Technical Note

Project:	Pendle Mill Pendle Road Clitheroe BB7 1JQ Ribbles Valley Borough Council Planning Application Reference 3/2022/0632	Project No:	300828-003-01
Subject:	Response to Lancashire CC Highway Authority Planning Application Comments		
Prepared by:	Ian Ladbrooke	Date:	12.08.2022
Checked by:	Karen Smith	Date:	12.08.2022

Ribbles Valley Borough Council Planning Application no: 3/2022/0632, Pendle Mill Pendle Road Clitheroe BB7 1JQ for the Demolition of existing buildings and erection of a care home (Use Class C2) of up to 70 beds. All matters reserved apart from access.

Site Area -
3930m² (0.39 hectares)

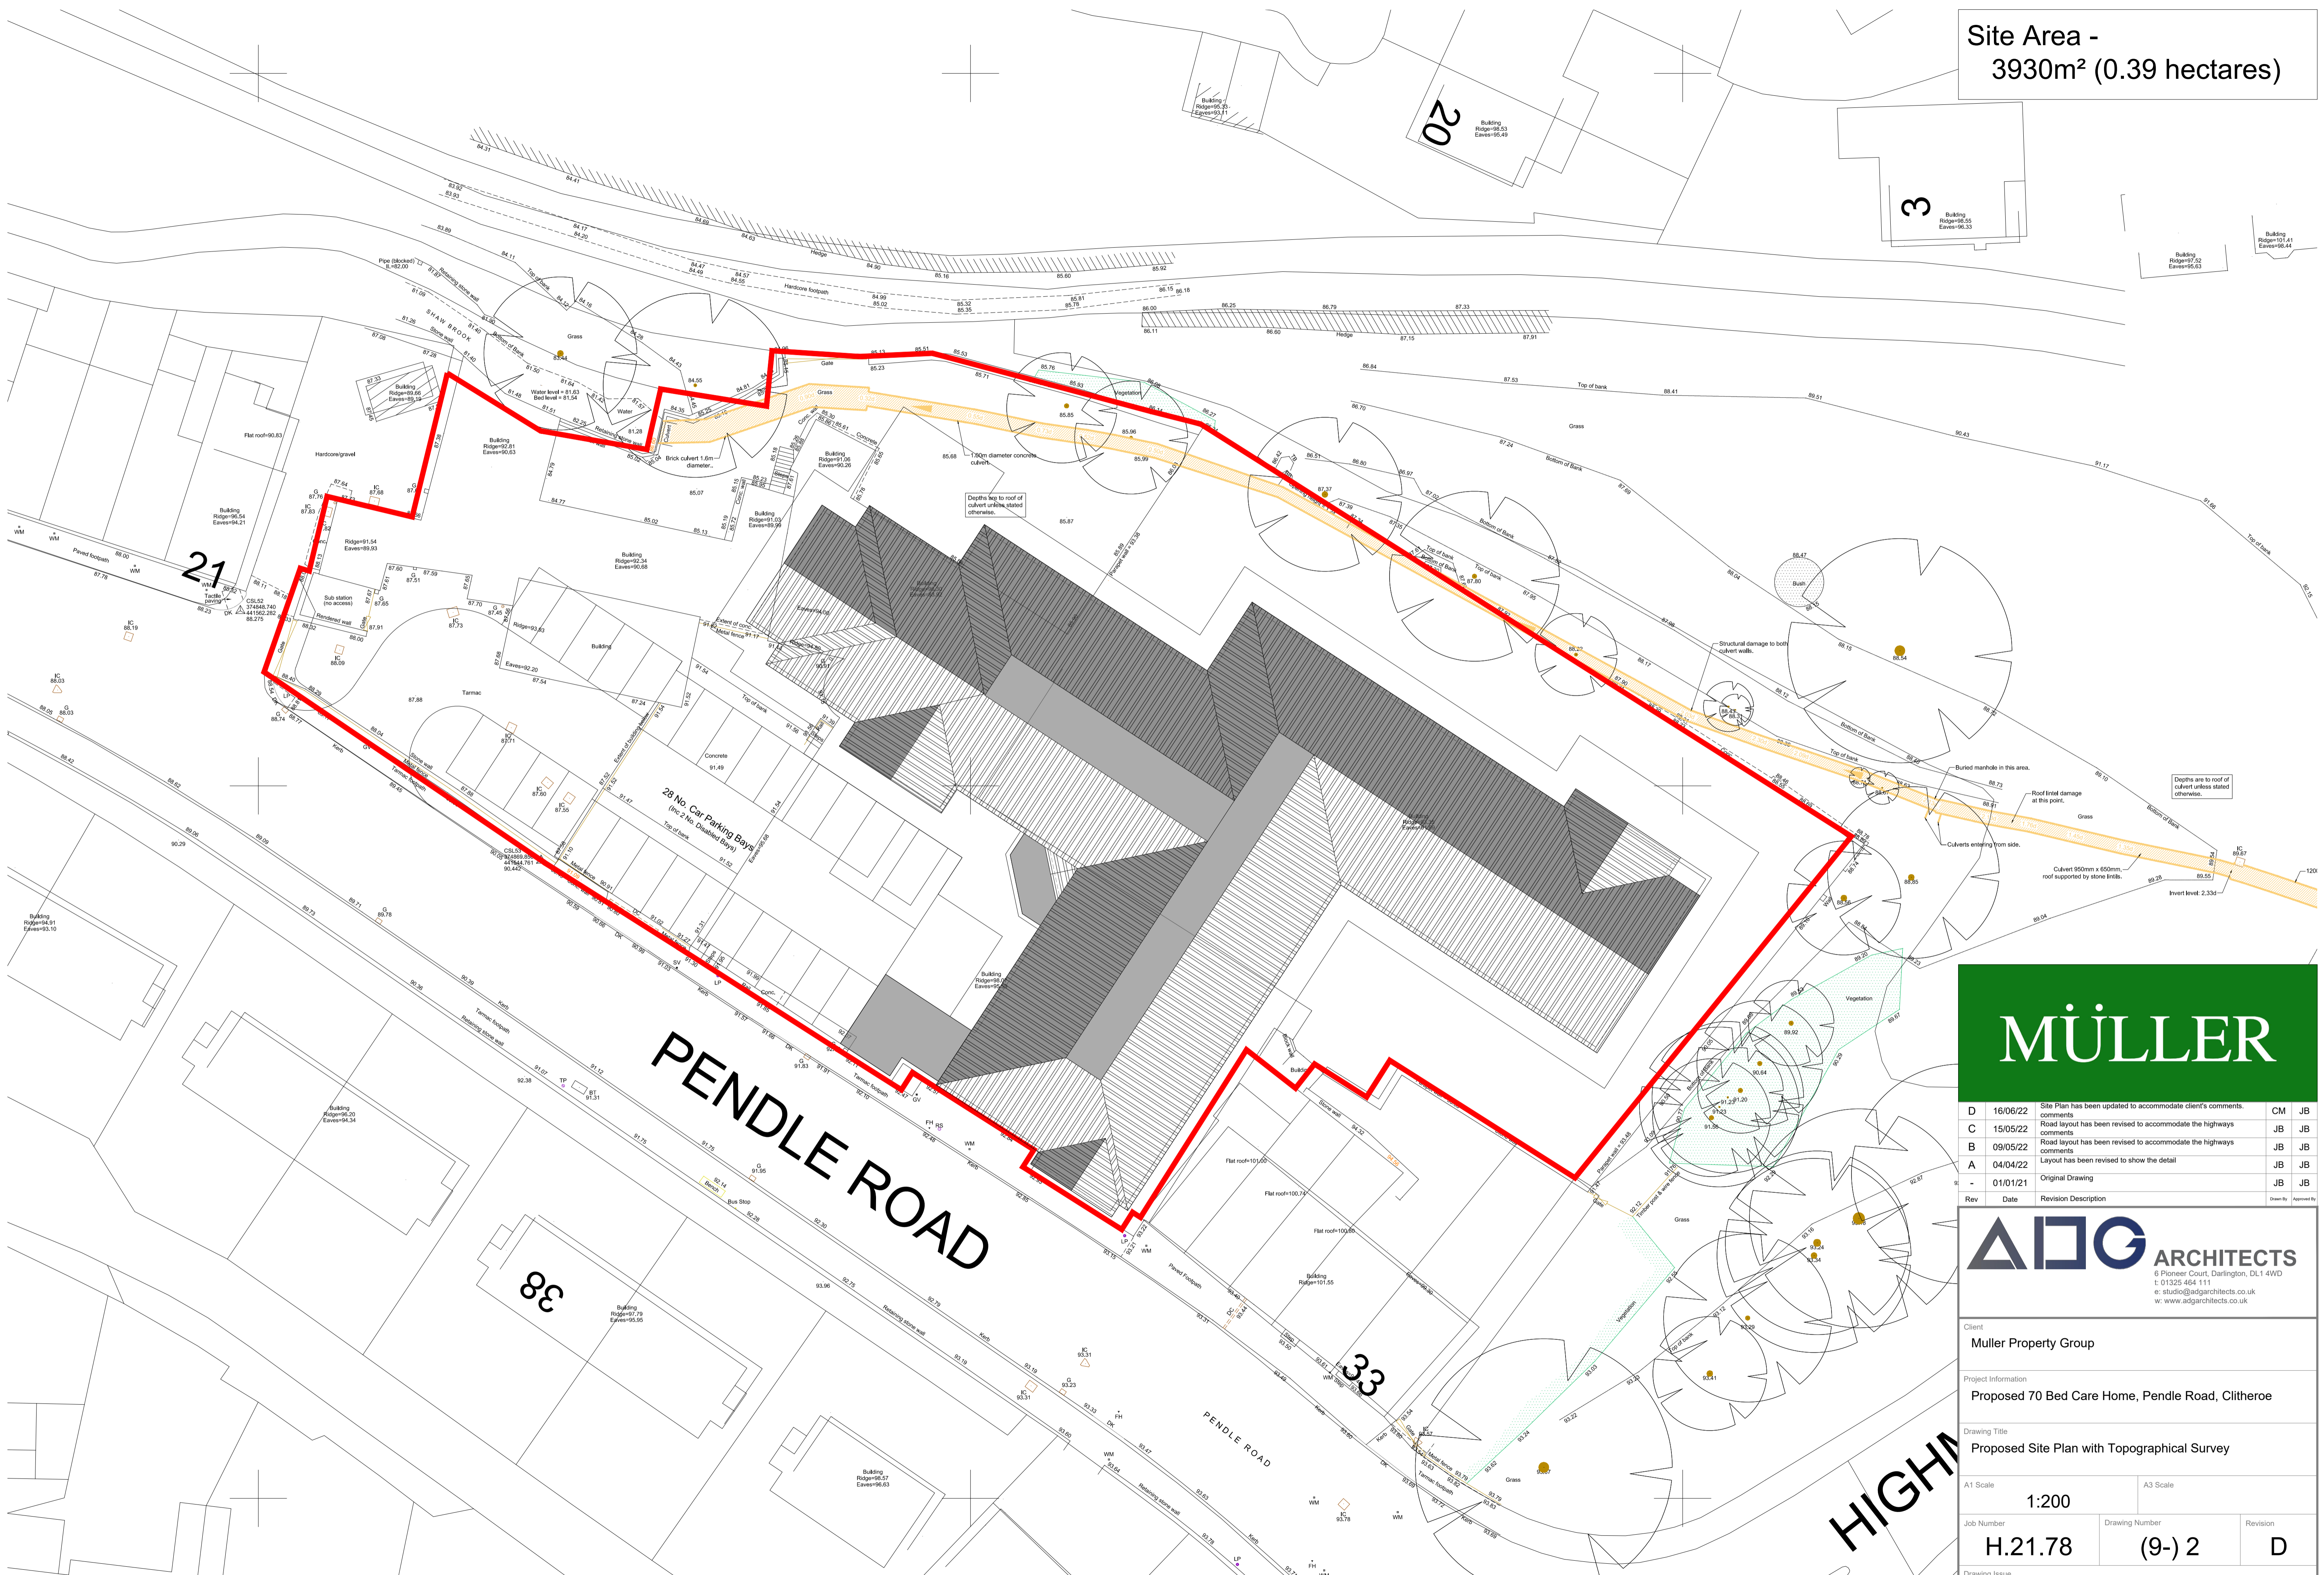
However, and again this can be addressed during the reserved matters stage, but the LHA advise that the parking space located in the visibility splay to the left of the access is realigned so that it is line with the first 4 spaces. This is because currently should a vehicle be parked in this space it will obstruct the accesses visibility.

The LHA are requesting further car parking spaces are provided to ensure that there is adequate parking spaces during shift changes and there is a minimum of one space per member of staff on site at any one time. More capacity is required to ensure that there is adequate number of parking spaces during visiting times for the residents. This is so that inappropriate parking does not occur on the highway.

The development proposes a total of 28 car parking spaces. The LHA state that 37 car parking spaces are required. Detailed justification for the level of car parking associated with the development is set out at Section 4.3 of the Transport Assessment. The residents of the care home will not require car parking spaces

as the nature of their condition would preclude them from driving. Car parking standards are set out in the 'Joint Lancashire Structure Plan' March 2005. For C2 Residential Institutions the parking standard for all development car parking (staff and visitors) is based on the number of residents with 1 space per 5 residents. Therefore 70 residents would require 14 spaces for staff and visitors. The Transport Assessment recognises that the anticipated staff contingent of this development requires further consideration for additional staff car parking. A further 15 spaces are proposed for staff which would be adequate for the number of staff on site at any one time. This is a significantly greater level of parking provision than set out within parking standards and reflects the operational requirements of the development without an over provision.

Existing Site Section A-A

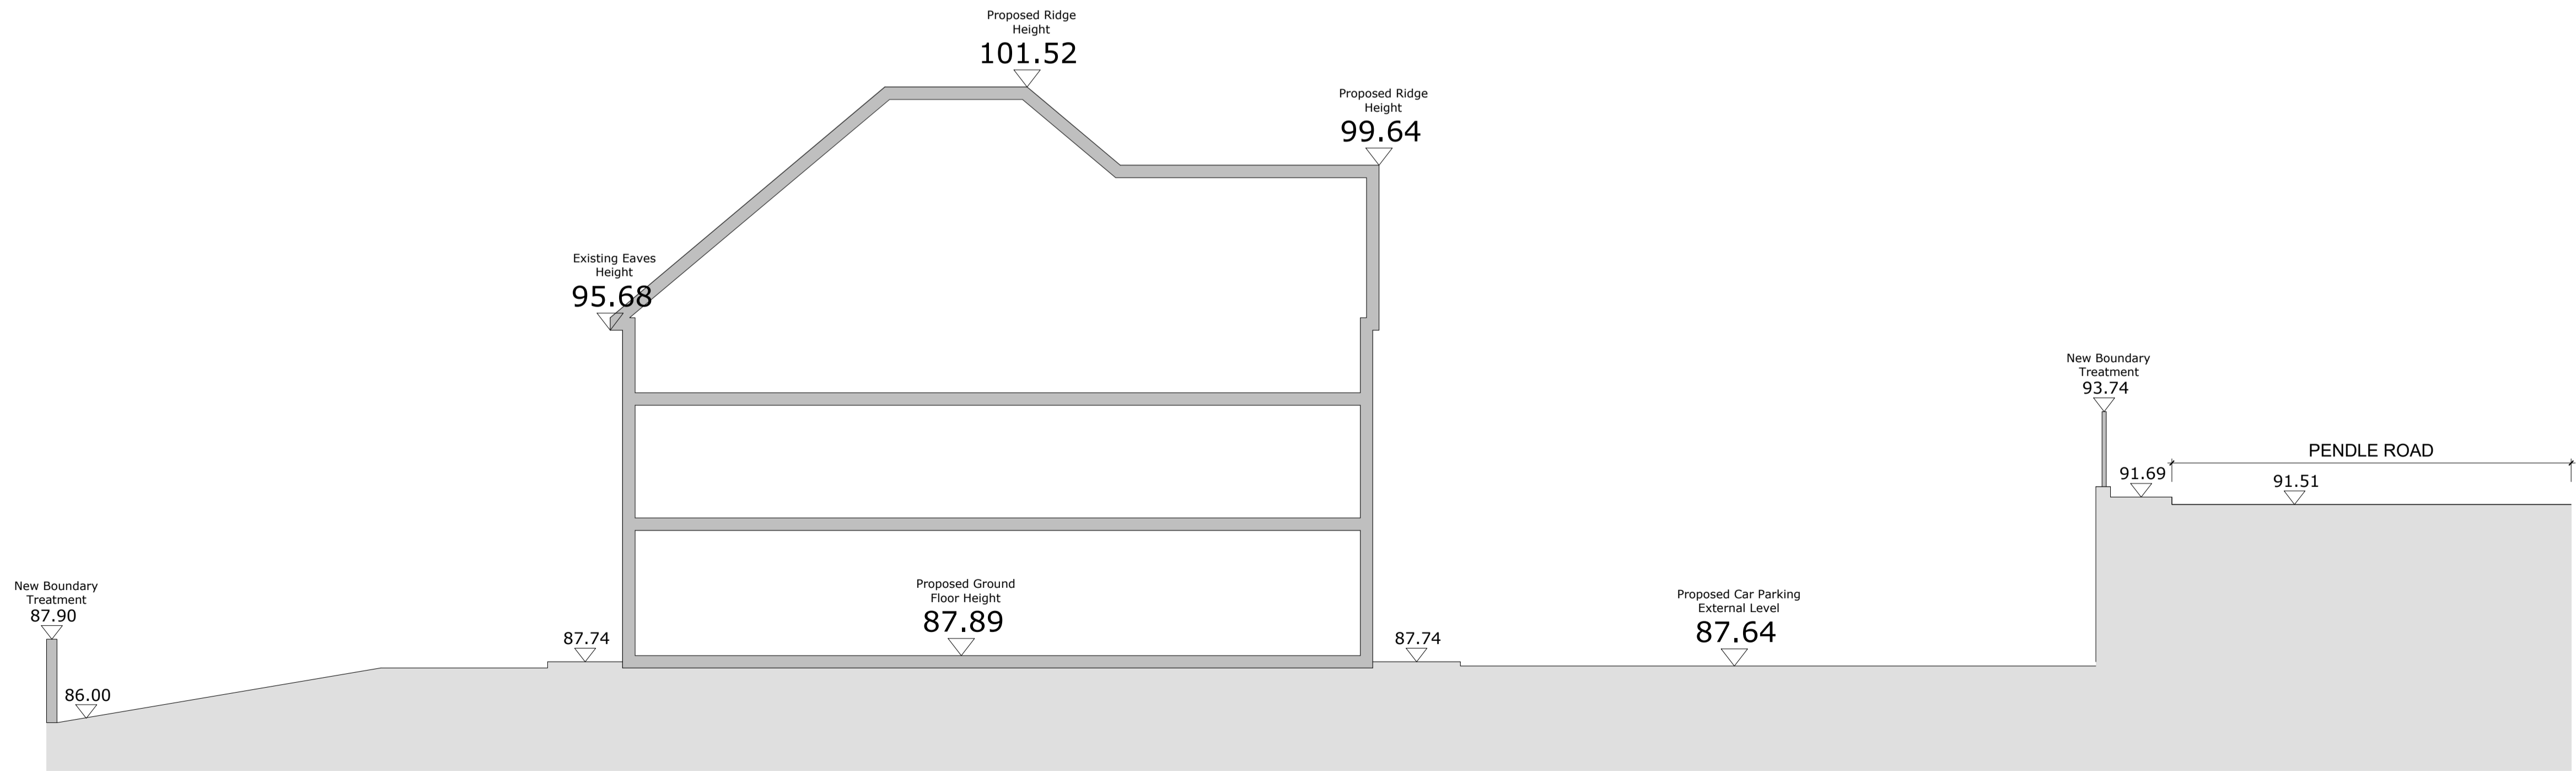
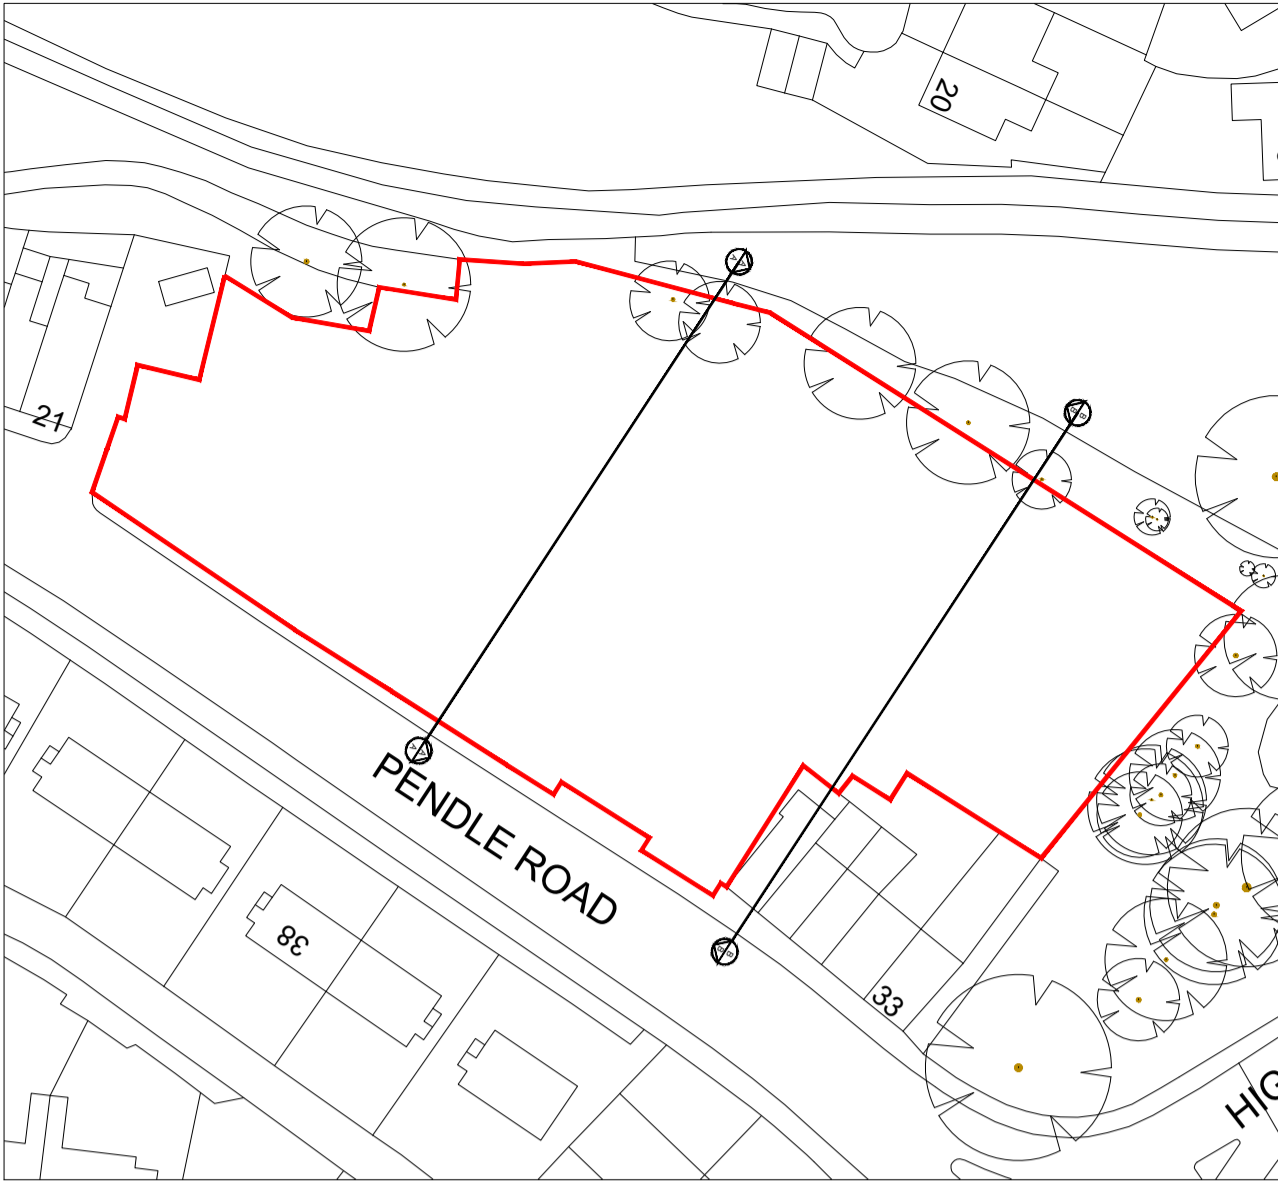
Before reviewing the technical details of the proposed access, the LHA are aware by visiting the site and by reviewing Google Streetview that there is a level difference at the proposed site access between the highway and the internal road network. To ensure that the difference is not greater than 1 in 20 for the first 5m behind the highway boundary, the LHA will require a site section drawing showing the change in levels at the site access is submitted. The LHA also inform the Agent and Applicant that any change to the retaining wall feature located at the back of the existing footway fronting Pendle Road, will need to be conditioned by the LHA. The LHA will require a technical drawing showing the new retaining wall. This is to ensure that any change in the retaining wall feature will not destabilise the adopted highway.

A site section is included at **Appendix B** which demonstrates a 1:20 gradient at the new site access location for the first 5m behind the highway boundary.
